**Modification to 50 Peter Brock Drive, Eastern Creek - Event Parking Area -  
(DA S29/3/97-Mod-1)**

Thank you for your email dated 16 April 2021, inviting WaterNSW to comment on the Response to Submissions (RTS) for the above development modification (MOD) and undertake an assessment of the proposal's neutral or beneficial effect (NorBE) on water quality in the Sydney Drinking Water Catchment. WaterNSW understands the proposal is to retrospectively approve earthworks undertaken in the south eastern corner of the site and to provide improvements to stormwater drainage infrastructure.

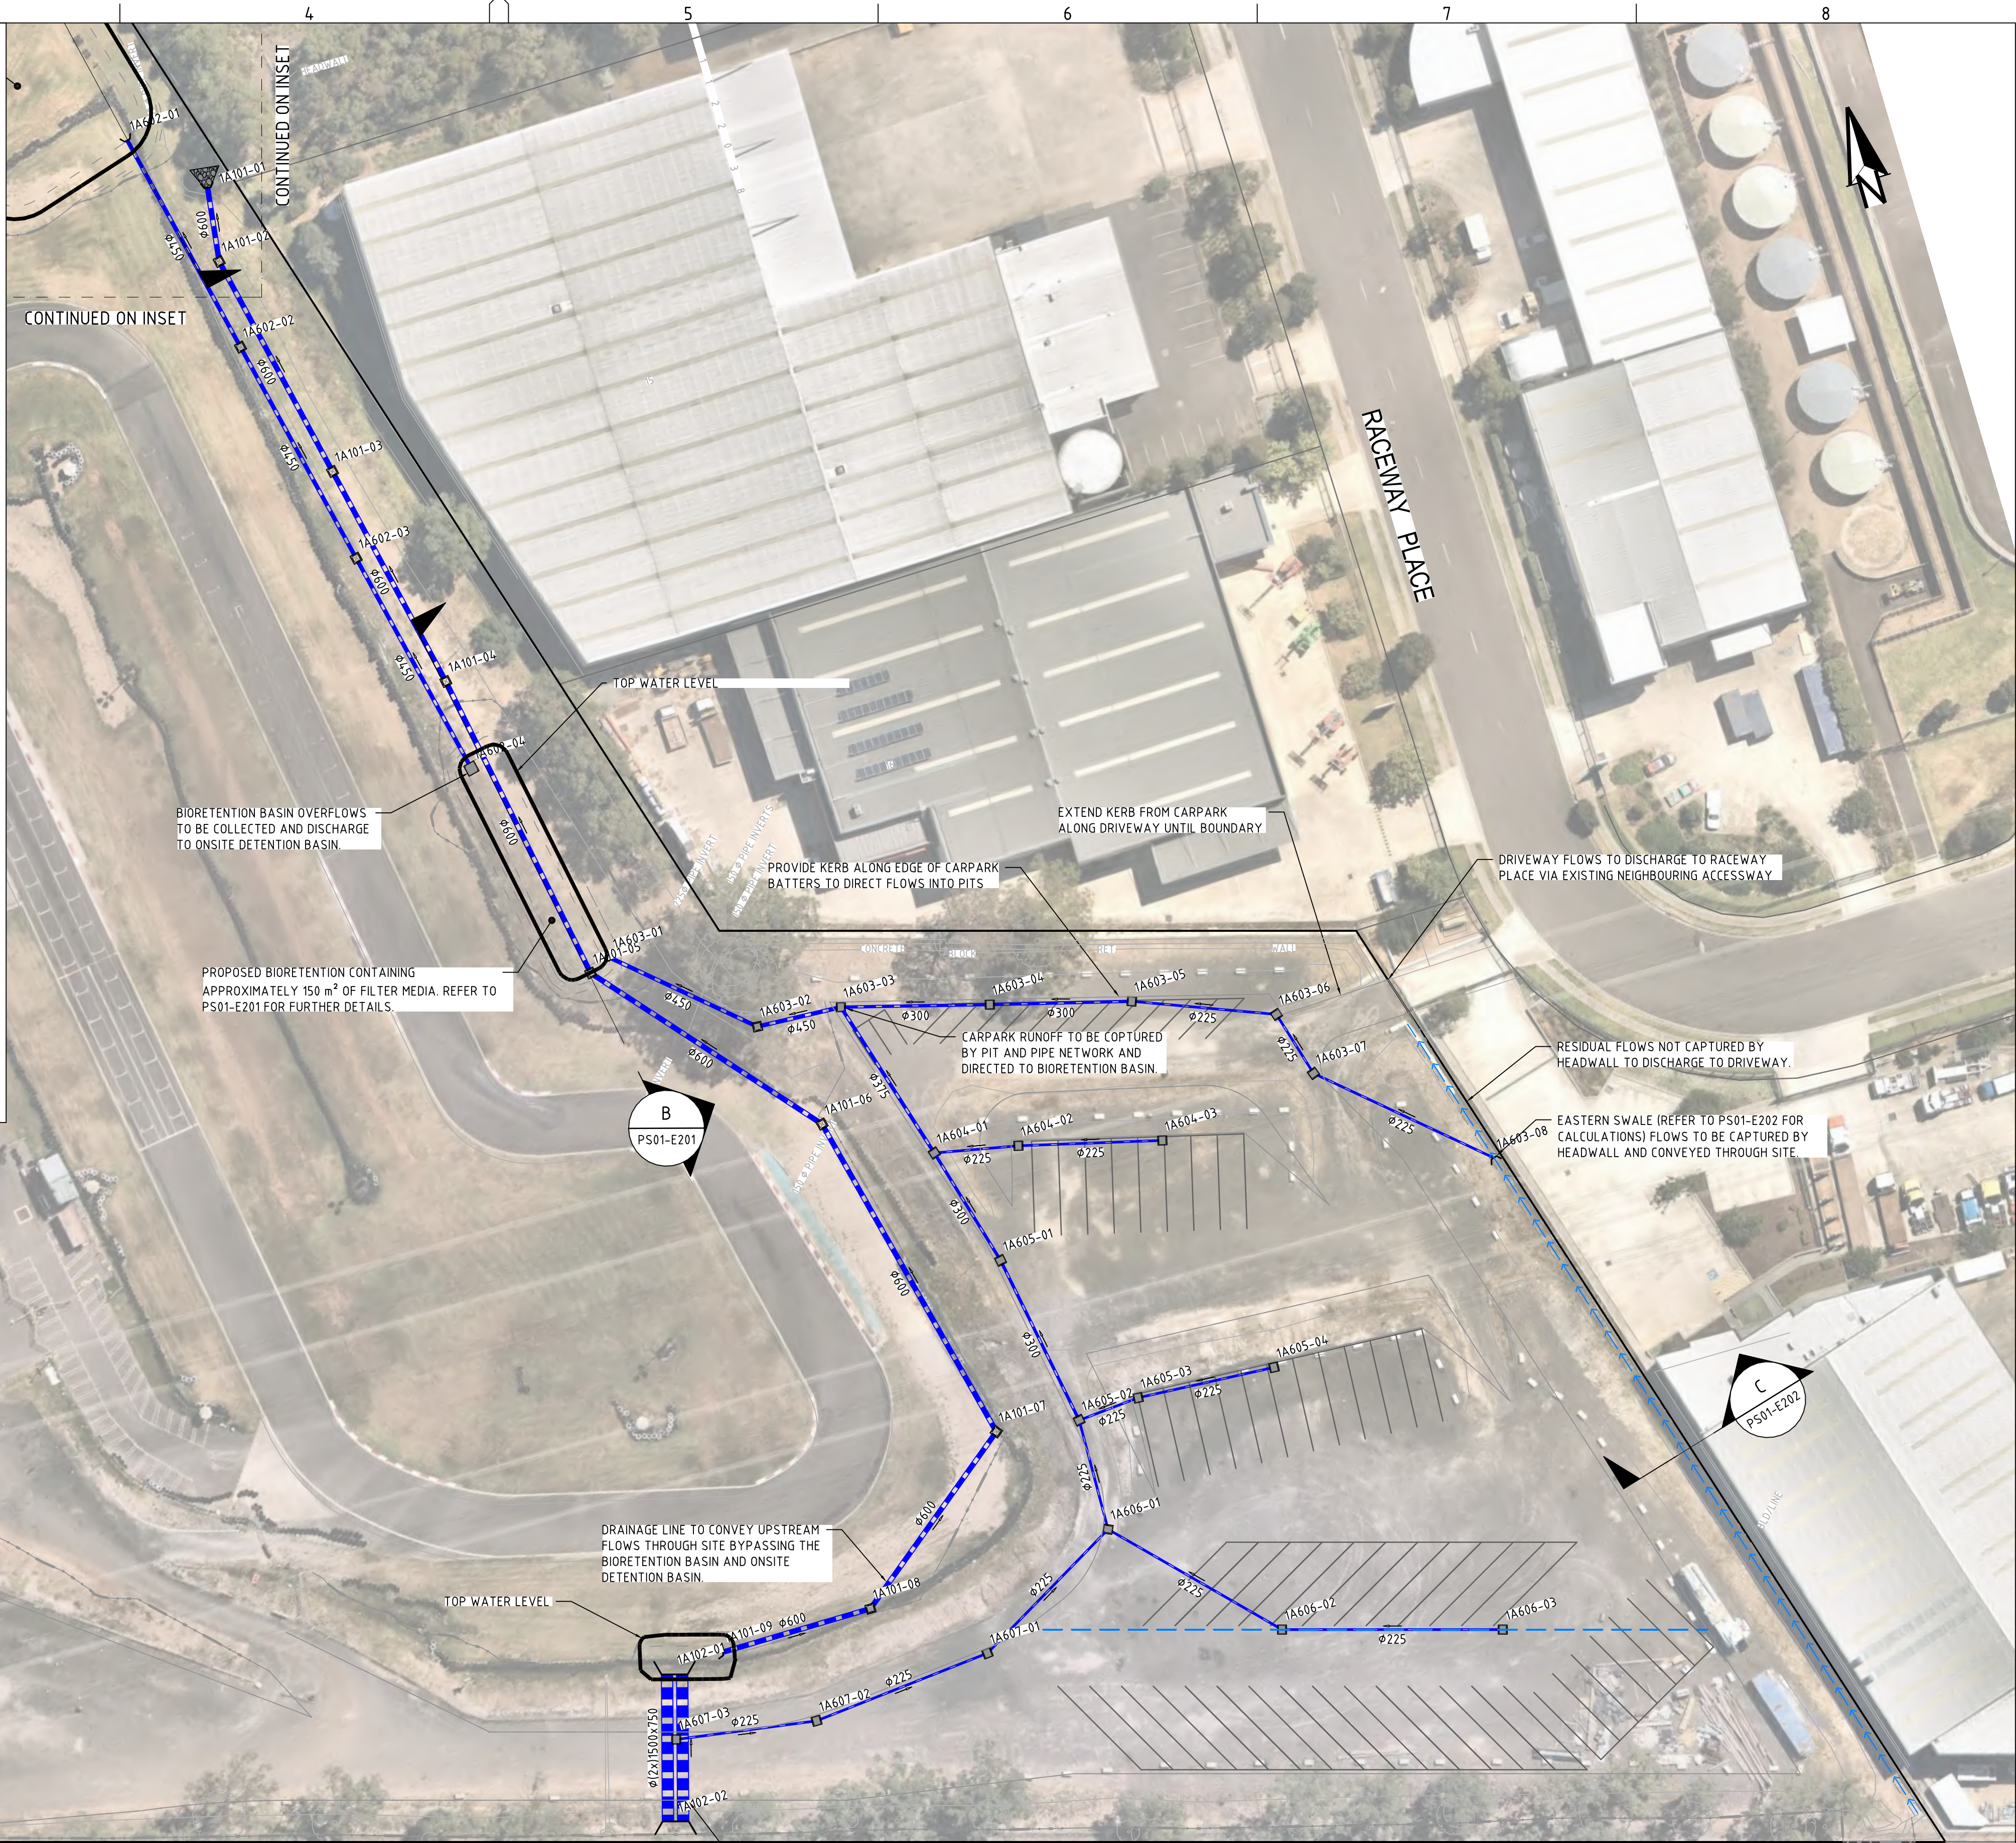
- *The swale drain (as indicated on the General Arrangements Plan C201 – SGC 16/11/20) must be installed on the southern boundary of the development area, to collect any surface water runoff from upstream catchments and direct it away from the Prospect Special Area.*
